From: Amanda Scholes on behalf of Planning.Responses
Sent: 21 December 2020 09:12
To: Planning Scanning
Subject: FW: F/25/20/AG -Application for Prior Notification for an open storage lean-to, Northwood Farm

From: Graham Abbot [REDACTED]
Sent: 18 December 2020 14:54
To: Anita Gardner <Anita.Gardner@arun.gov.uk>
Subject: Re: F/25/20/AG -Application for Prior Notification for an open storage lean-to, Northwood Farm

NORTHWOODS FARM OPEN PLAN LEAN TO
PLAN & ELEVATIONS Scale 1:200

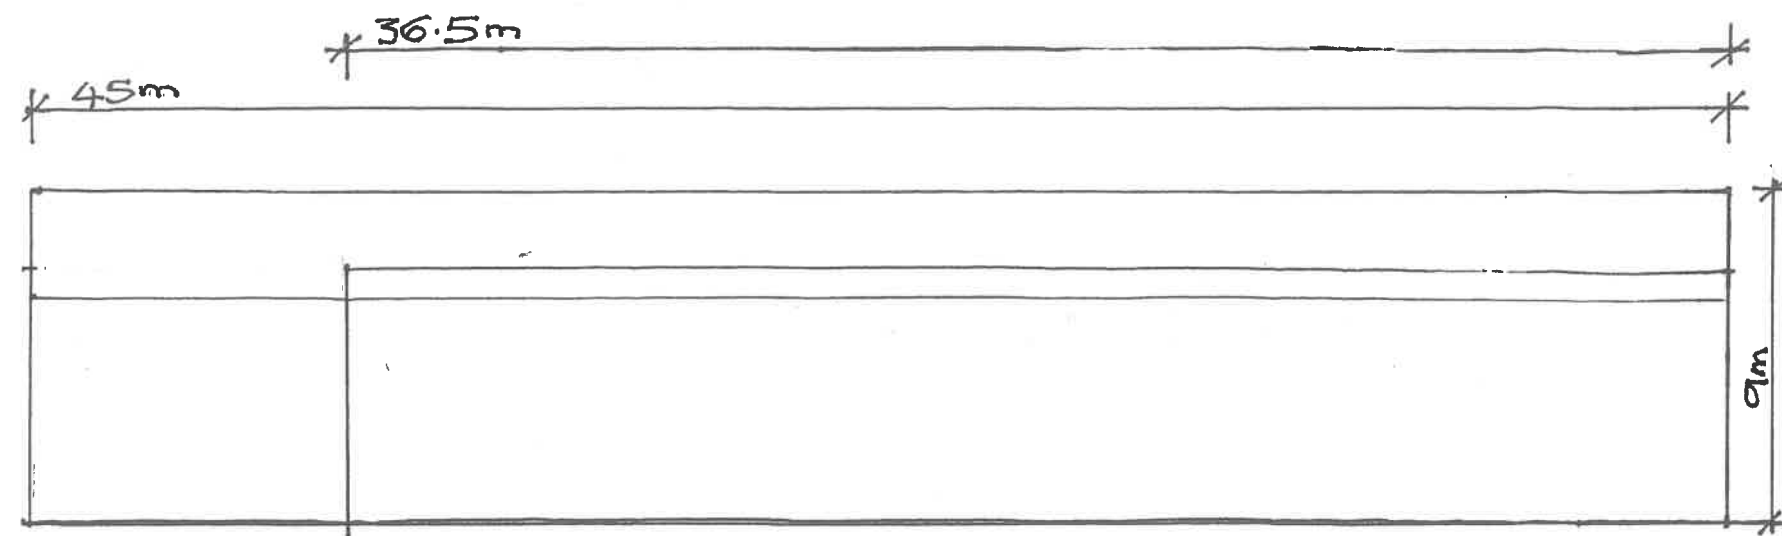
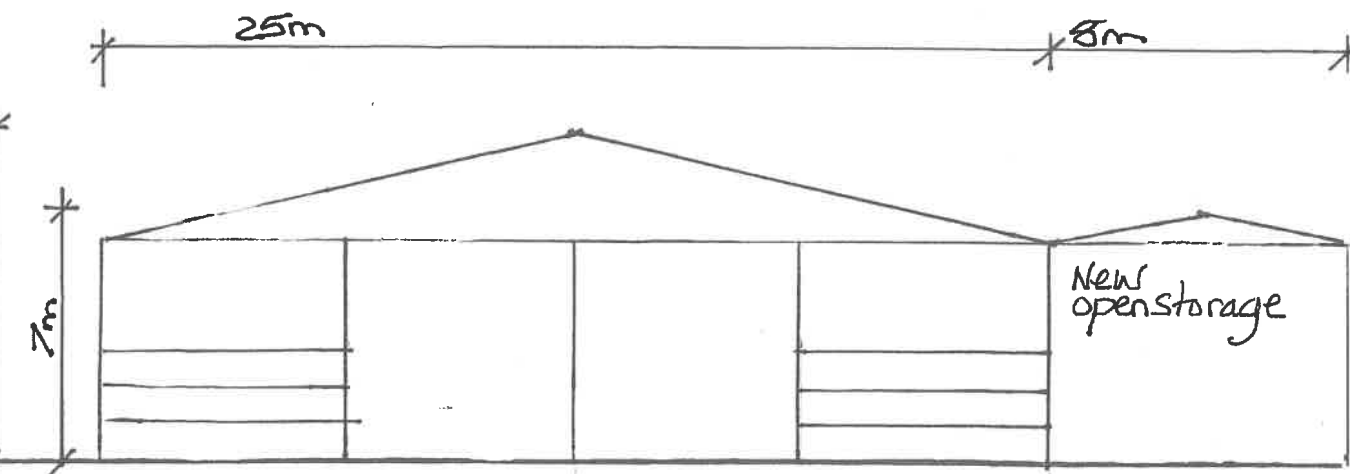
Thanks for responding so promptly. Can you also confirm why the 7m ridge height is necessary. I assume it is to accommodate the height of equipment stored. Is there a particularly tall item that requires this space?

The height is because if it followed the line of the grain store roof it would only be 4 metres at the side and you wouldn't be able to get anything in. It is the gutter height that matters and it is the same as the existing grain store and the pitch of the roof is the same as well. i have tried to copy the existing as much as possible.
